CITY OF ALBUQUERQUE

April 21, 2021

Re: Lowes Market# 99 Dock Addition
4701 4th NW
Traffic Circulation Layout
Engineer's Stamp 03-10-2021 (F14-D052)

Site Plan

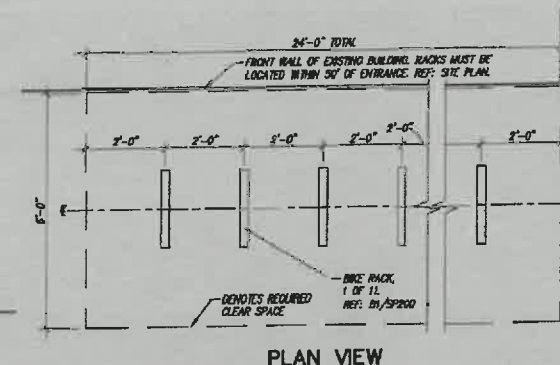
1. List the number of parking spaces required by the IDO as well as the proposed number of parking spaces including bicycle and motorcycle parking and **discuss with Zoning (If applicable)**.

2. **Delivery Vehicle:** You show the egress of the delivery vehicle but not the ingress so need to show the ingress turning movements and the entrance driveway being impacted by this maneuver.

3. **Monument Sign:** Make sure that this structure is located on private property. This includes air space.
4. **Bollard:** Add note to paint bollard yellow.

5. **Key Note 10:** Provide detail.
6. Architectural/civil references on key notes will need to be provided on submitted site plan **(If applicable)**.
7. Please identify all existing buildings **doors**, structures, sidewalks, curbs, drive pads, wall and anything that influences the parking and circulation on the site.

8. **Identify all existing access easements and rights of way width dimensions.**
9. **Identify the right of way width, medians, curb cuts, and street widths on Griegos Road and 4th Street.**

10. Clarify existing property lines and proposed property lines.
11. Maximum access width for **arterial**, collector, and local streets are as follows:

12. Please list the width and length for all existing and proposed parking spaces. Some dimensions are not shown.

14. The ADA accessible spaces must include an access aisle. Van accessible aisles should be 8ft wide; all others should be 5ft wide.
15. The ADA access aisles shall have the words **"NO PARKING"** in capital letters, each of which shall be at least one foot high and at least two inches wide, placed at the rear of the parking space so as to be close to where an adjacent vehicle's rear tire would be placed. **(66-1-4.1.B NMSA 1978)**

16. Griegos/4th St. corner: ADA curb ramps must be updated to current standards and **have truncated domes installed**.
17. 4th St. Entrance: The ADA ramps are located on private property so you will **need a sidewalk easement** for this issue

18. Existing sidewalk on both public frontages: **Provide existing width.**
19. Motorcycle parking spaces shall be designated by its own conspicuously posted upright sign, either free-standing or wall mounted per the zoning code. Provide signage face detail.

20. List radii for all curves shown; for passenger vehicles. Radius for **delivery trucks**, fire trucks, etc. is **25 ft. or larger**. Will the proposed driveway be able to handle the ingress of delivery vehicle?

21. Per the IDO, **a 6 ft. wide ADA accessible pedestrian pathway is required from the public sidewalk to the building entrances**. Please clearly **show this pathway and provide details**.

22. Per DPM, a 6 ft. wide ADA accessible pedestrian pathway is required from the ADA parking stall access aisles to the building entrances. **Provide the accessible routes width fronting building and verify existing ramp is ADA accessible/current design.**

23. Proposed bike rack **should not** interfere with the **6 ft width and pathway of ramp**.
24. Parking areas shall have barriers to prevent vehicles from extending over sidewalk **(decrease the existing width)**.

27. Please provide a sight distance exhibit
28. Show the clear sight triangle and add the following note to the plan: "Landscaping and signage will not interfere with clear sight requirements. Therefore, signs, walls, trees, and shrubbery between 3 and 8 feet tall (as measured from the gutter pan) will not be acceptable in the clear sight triangle.

### Site Details

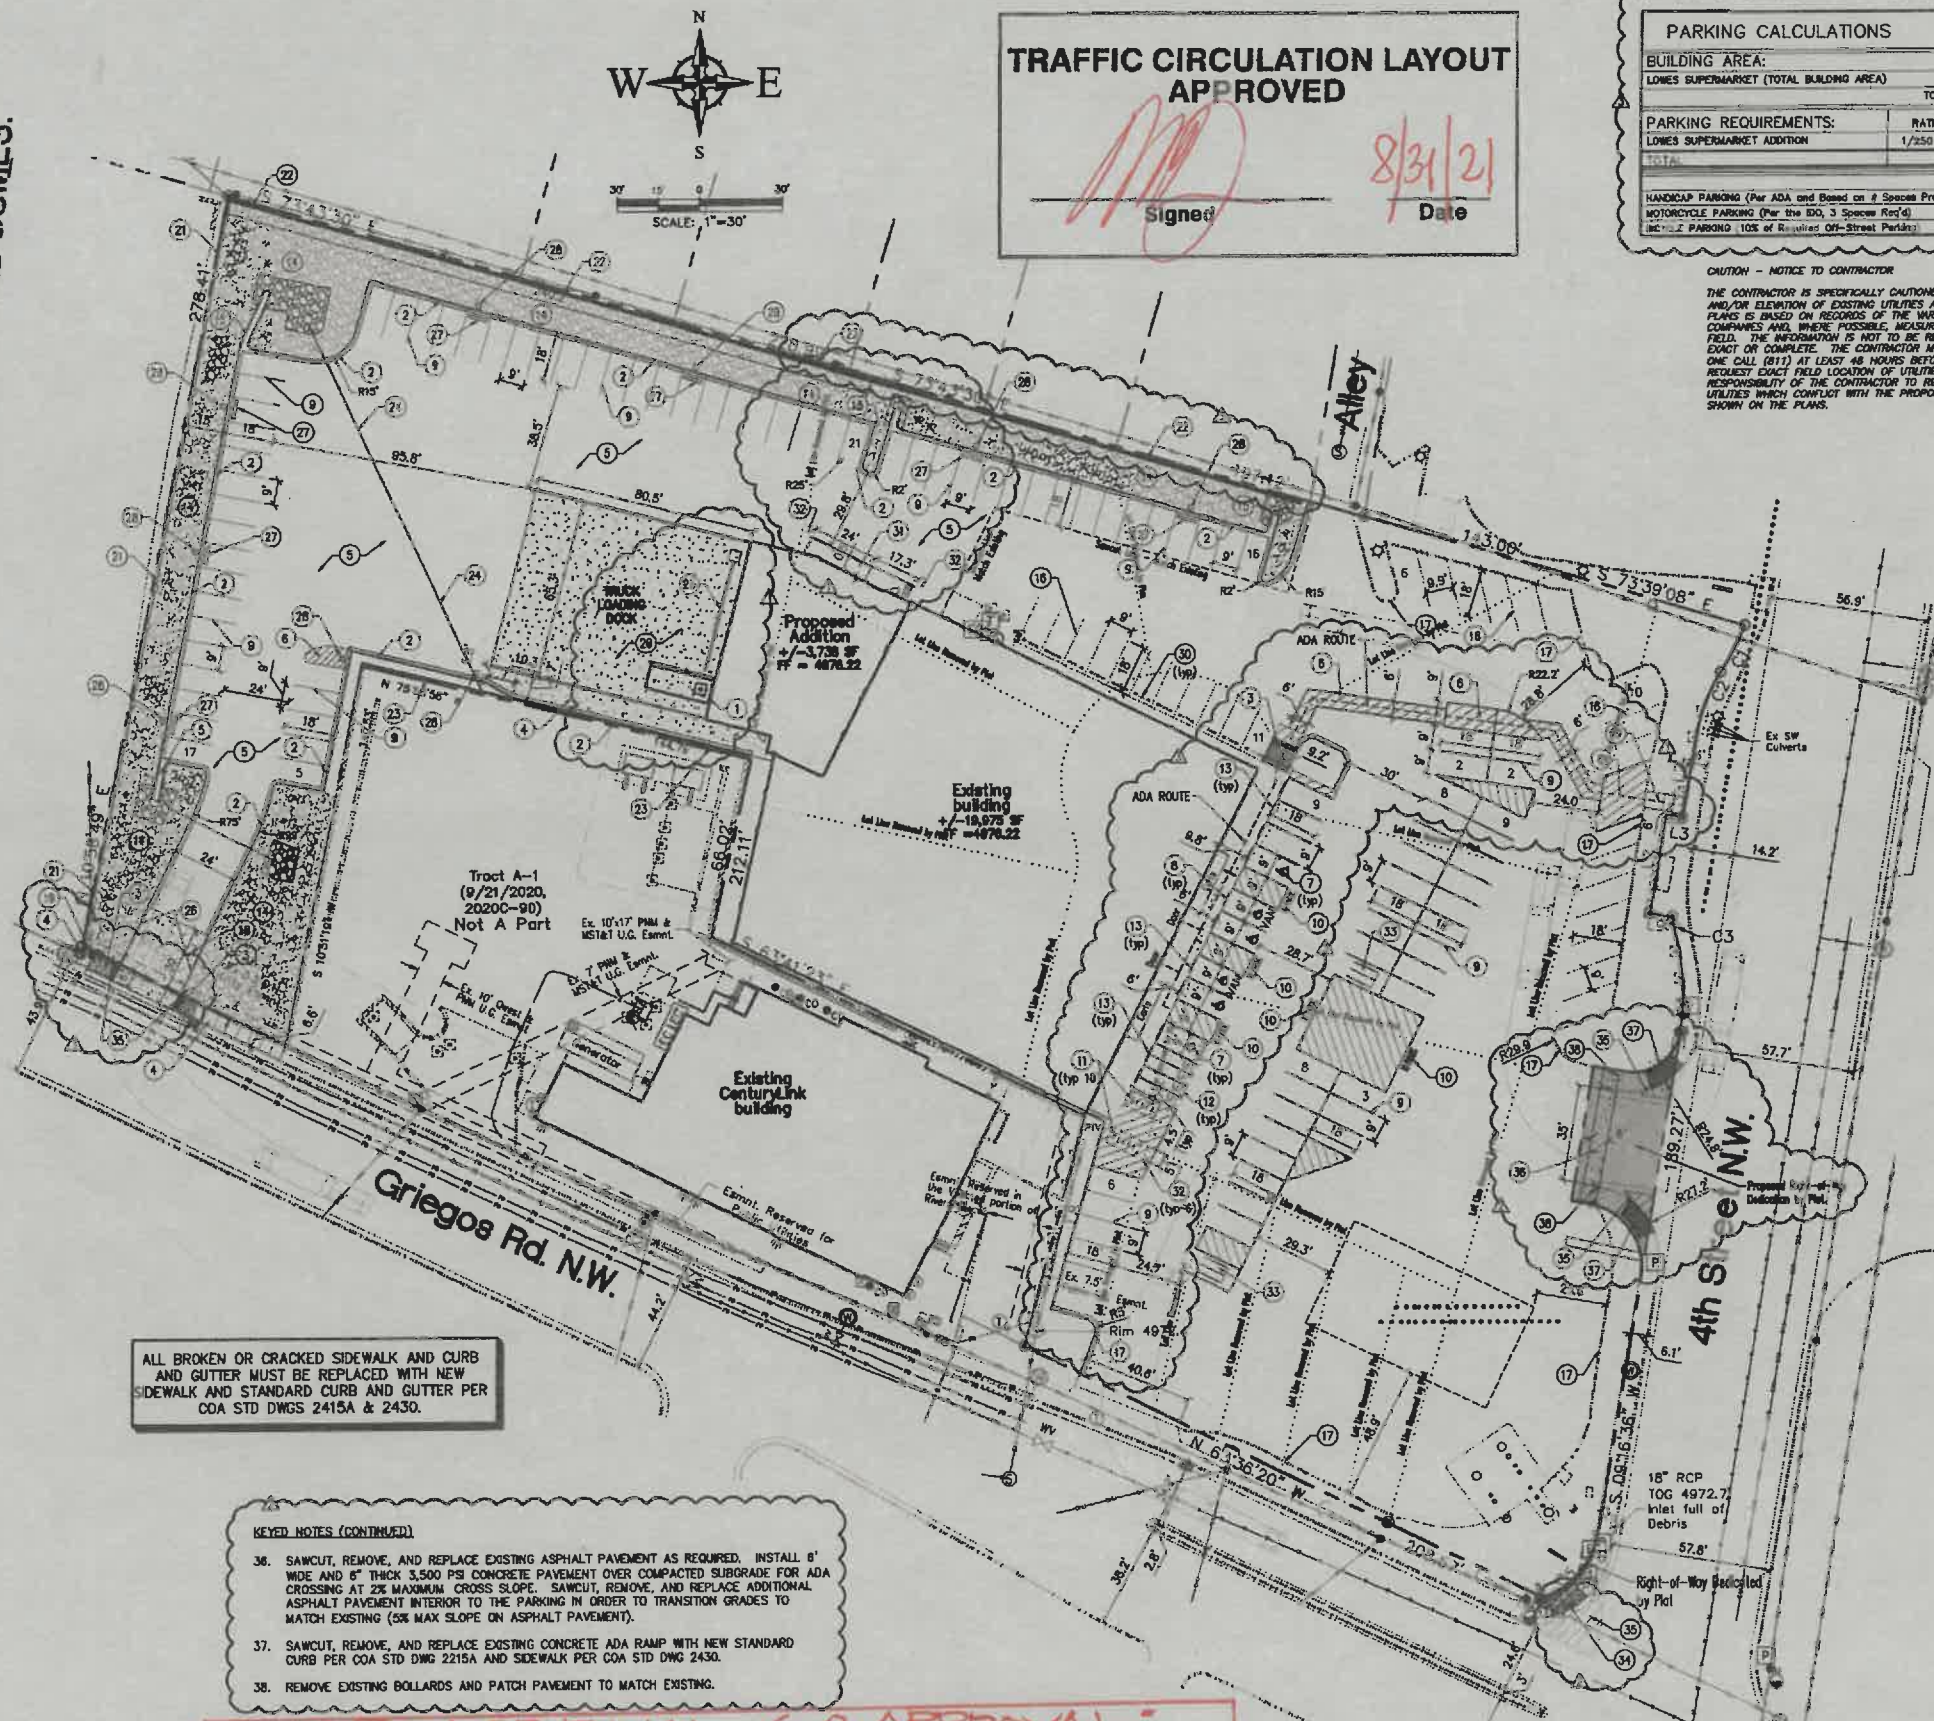
25. You will need to provide a full detail (include slope/grades and lengths) of the **proposed hand rail on A1/SP200**.
26. Provide a copy of refuse approval.
